December 22, 2016

Deepesh Kholwadwala, Dreamcatcher ABQ North, LLC: deepesh@suncapitalhotels.com  
Fairfield Suites: 4875 Pan American Frwy NE

**Re: Drainage Control Ordinance (14-5-2-1) and NPDES CGP Violations for Erosion and Sediment Control- Fairfield Suites**

### Silt Fence

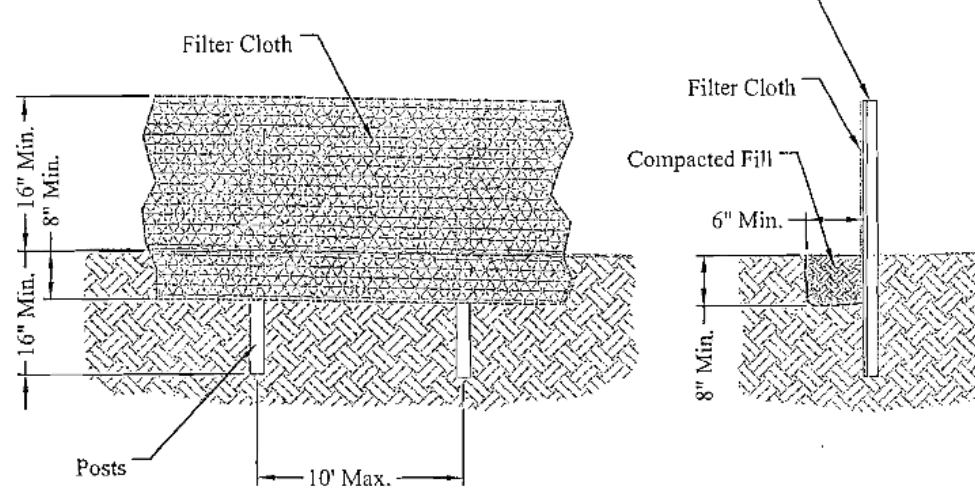
1. Drainage was observed leaving your site and entering the PNM substation. The photos were taken at 12:00 PM and it was still raining.
2. Numerous instances of cement pollution were observed and an acceptable concrete wash-out was not onsite.
3. Dirt was piled-up against the silt fence higher than halfway.

Dirt piled-up against silt fence.

3. Remove soil from the silt fence so it is below halfway up the silt fence.
